1 k) Original Flooring Treatment

Heritage Council Comment 1 k)

TONKIN ZULAIKHA GREER ARCHITECTS FOR INFRASTRUCTURE NSW	15/01/2018	WALSH BAY ARTS AND CULTURAL PRECINCT	SSDA	RESPONSE TO SUBMISSIONS - SSD 8671	56/65
---	------------	--------------------------------------	------	------------------------------------	-------

Figure 81: Proposed Ground Level Wharf 4/5 Floor finishes highlighted in red existing Ironbark to remain exposed.

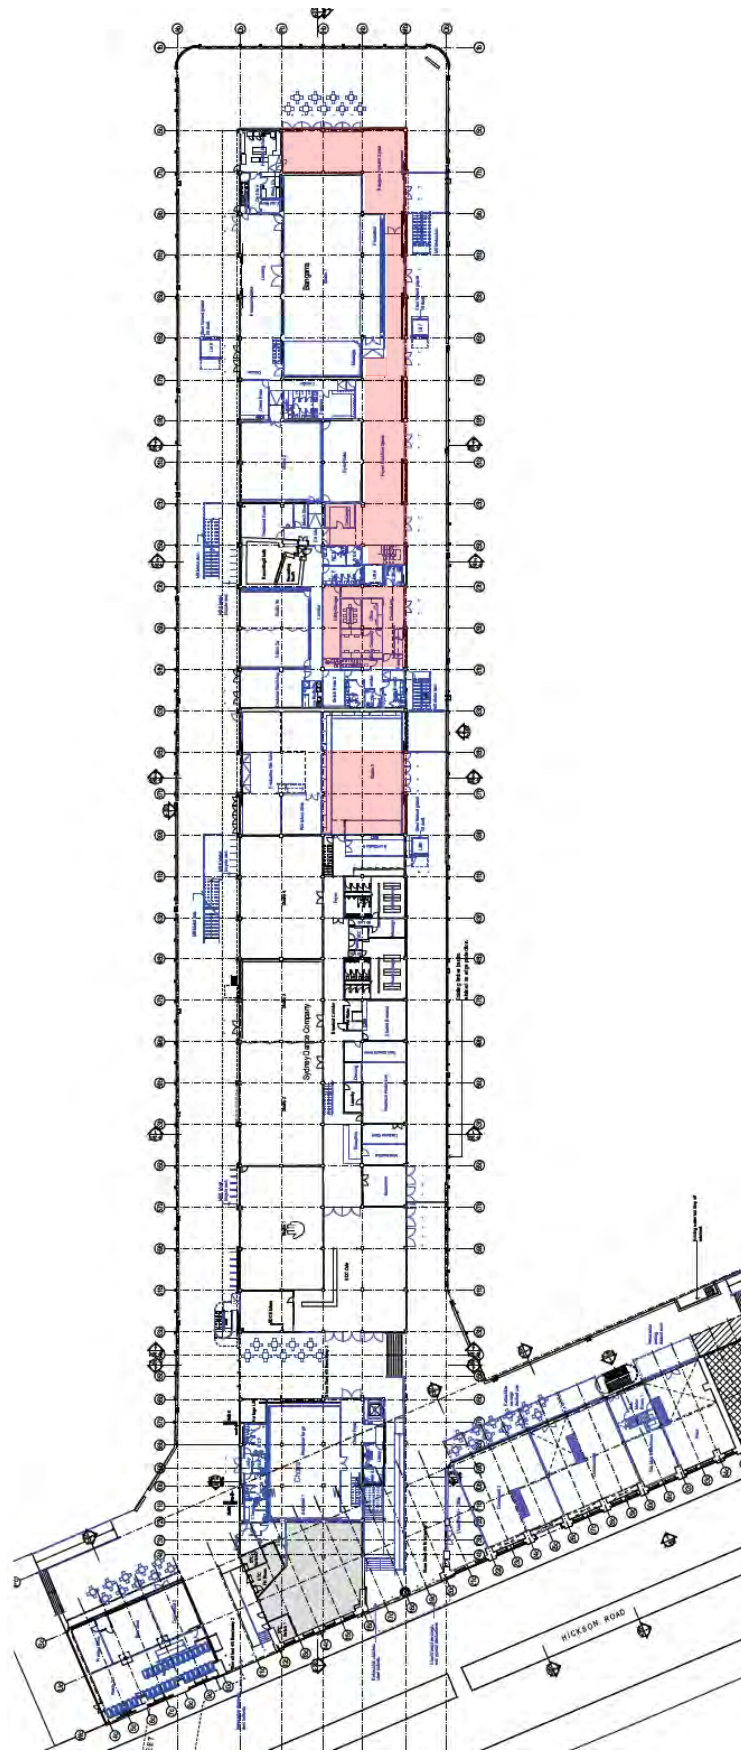
The original ironbark flooring in both Wharves is proposed to be retained in-situ. However, new flooring is required in areas such as kitchens and toilet facilities. Further design details of how the ironbark flooring will be retained and protected prior to the new flooring structure being installed above must be provided to the Heritage Council for assessment prior to approval of this project.

The original ironbark flooring is to be generally retained and protected. Where new finishes are proposed over the original flooring a double layer of 0.2mm thick plastic sheet, taped and sealed, will be installed to protect the original timber flooring from damage.

Equitable access underpins the adaptive reuse of the pier. To comply with accessibility codes it is necessary to remove the top layer of the original timber flooring in limited areas such as to the accessible bathrooms and commercial kitchens. The extent of this intervention has been carefully considered to minimise heritage impact, and is restricted to floor types 3, 8, 9, 10, 40, and 44.

The original ironbark flooring is a heritage feature of the building. The current proposal will retain the ironbark flooring in full, and where it cannot be exposed, it will be protected and preserved. Where programmatic requirements necessitate a different floor type, such as wet areas, the ironbark will be retained and protected prior to the new floor structure being installed.
